Recommendation Report for Prior Notification of Work to Tree(s) in a Conservation Area

REF NO: **WA/37/14/TC**

LOCATION: Lodge Cottage
 The Street
 Walberton

PROPOSAL: Prune back easterly lateral growth by 1.5 metres to 1 No Magnolia Grandiflora and 1 No Fig tree, fell and grub out dead and dying Leylandii and remove 1 No Purple Malus within the Walberton Village Conservation Area.

LODGE COTTAGE, THE STREET, WALBERTON, BN18 0PT

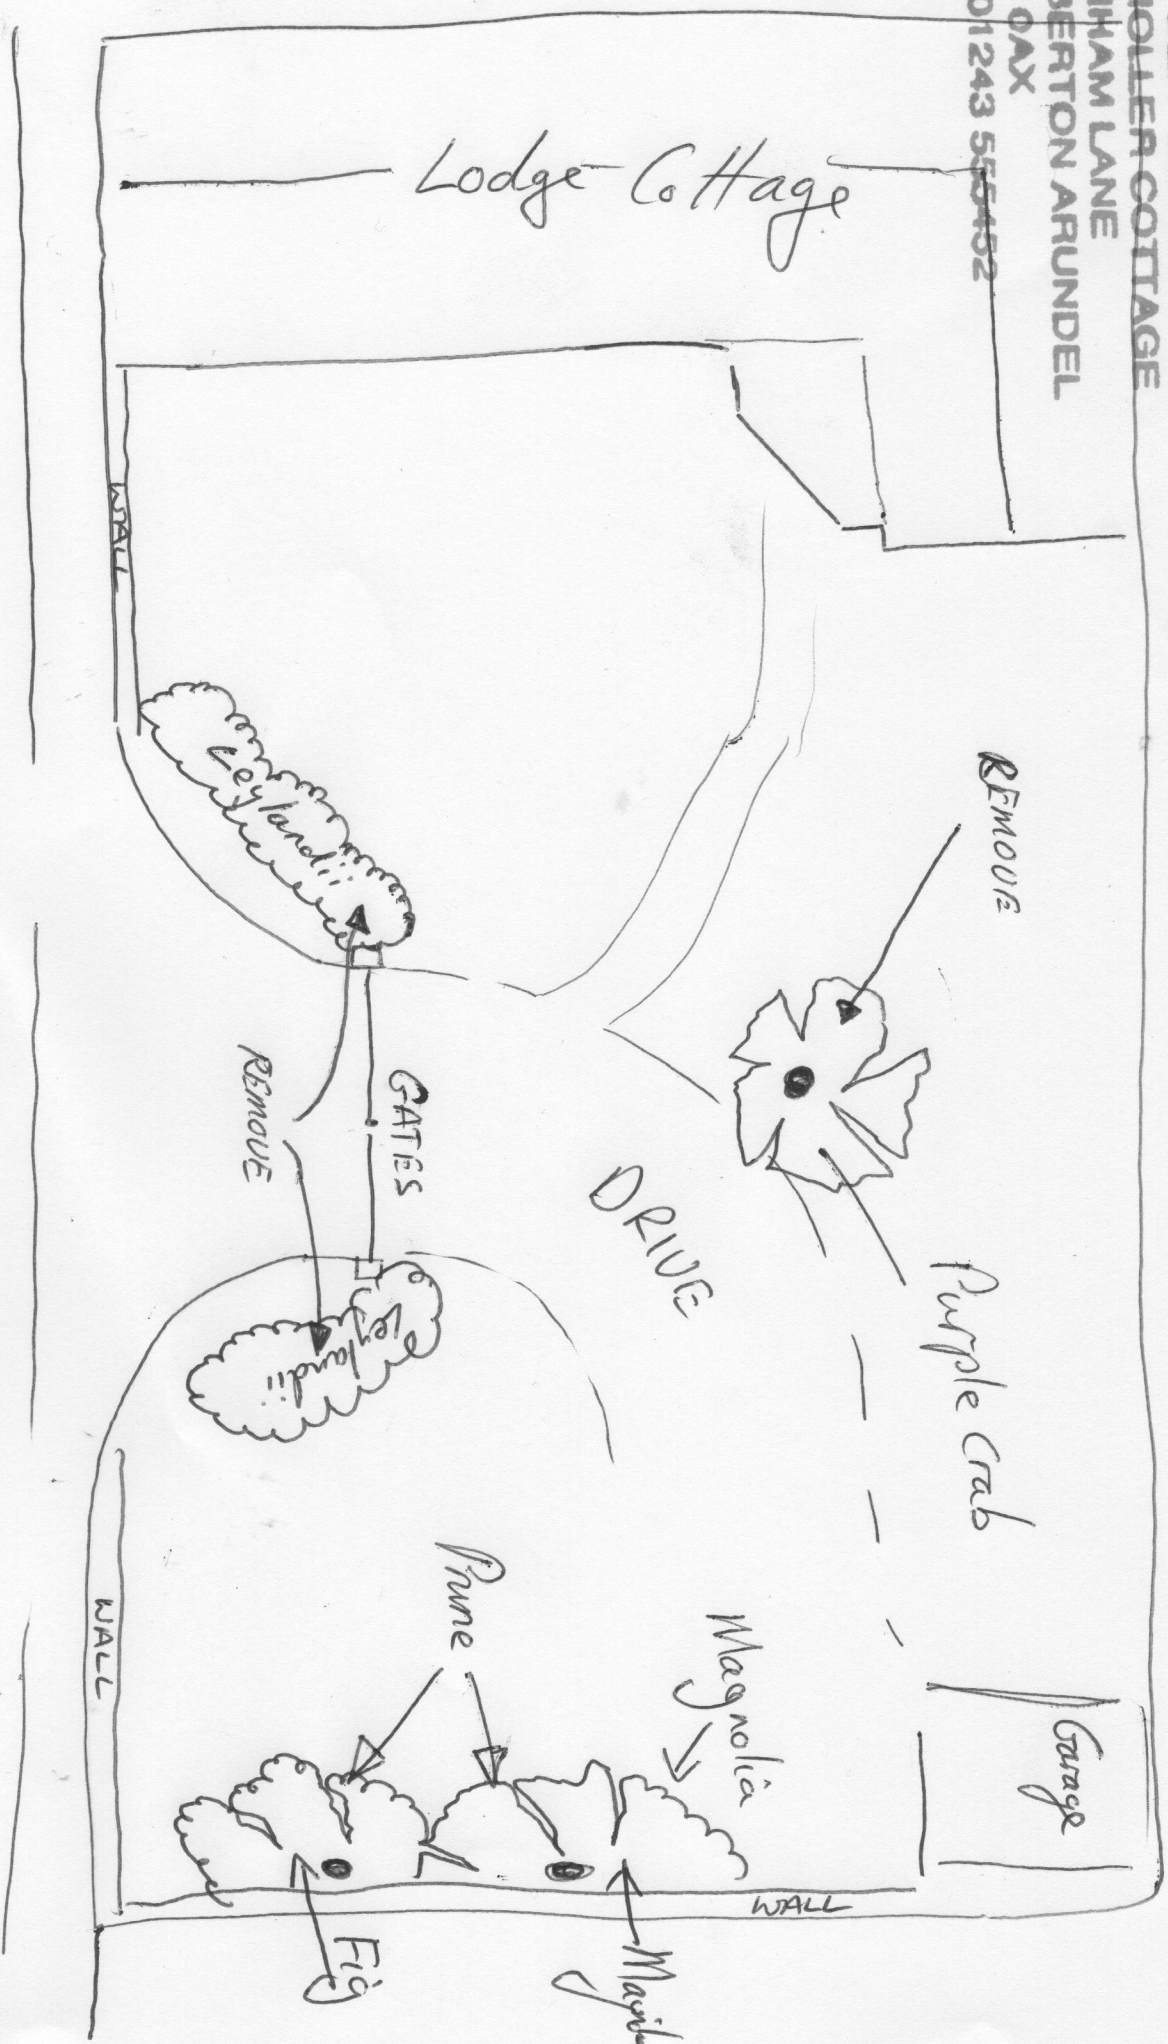
- Outlined trees are located in the high amenity area of Walberton village.
- All trees can be seen from the main road, due to their size however they have a limited impact on the landscape.
- T-1 has leaned over significantly to the east, and would benefit from a reduction to allow apical growth to prevail.
- T-2 has also got a lean to the east, should be rebalanced with an easterly reduction.
- T-3 is in fair to poor condition. It has been pruned regularly, however foliage has started to die off in areas. It is also over a meter wide, and is encroaching into the garden area.
- T-4 is in a poor condition, with less than 50% of the crown density you would expect from a healthy specimen of this species.
- Also the planting of a beech hedge along the boundary line would be in keeping with the landscape of the village, and arboriculturally speaking is sound practise.

- It would therefore be my recommendation that this proposed application of works should be allowed with the below conditions.
